Christina Stacey - RE: After-the-fact deck permit, 801 Brighton Ave.

I am in the process of reviewing your application for after-the-fact approval of the deck. Although this is after-the-fact, we do need some information on how the deck was constructed. Could you provide the construction details (spacing of joists, how attached to house), or at least a few good photos showing underside, attachment points, etc.? This can be e-mailed directly to me.

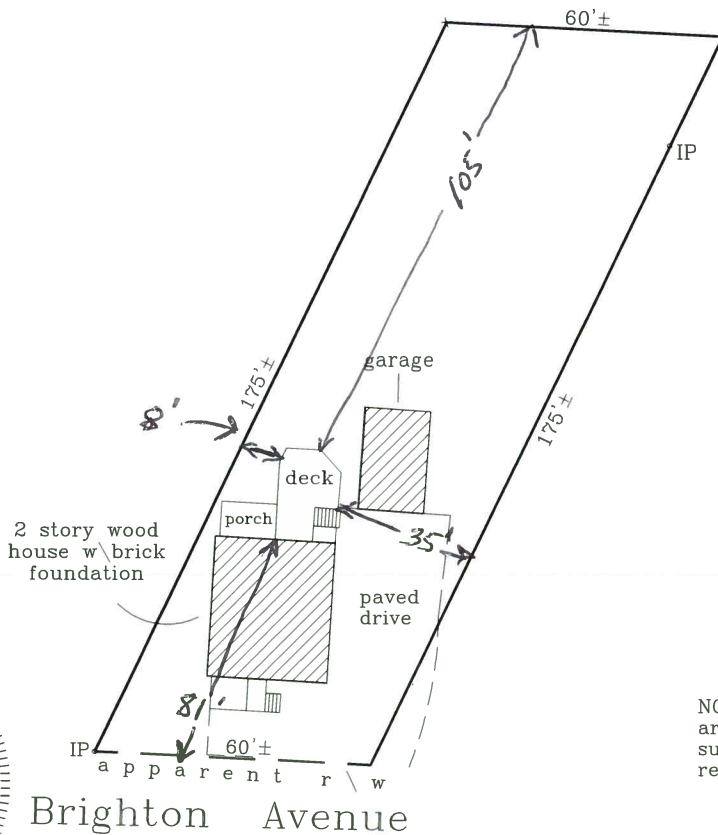
Also, could you provide the dimensions of the deck? Scaling off the plan it appears to be about 13.5' by 20' but if you could confirm the actual figures that would be great.

Attached are a few pictures of the deck. The actual dimensions are 13.5 x 12.
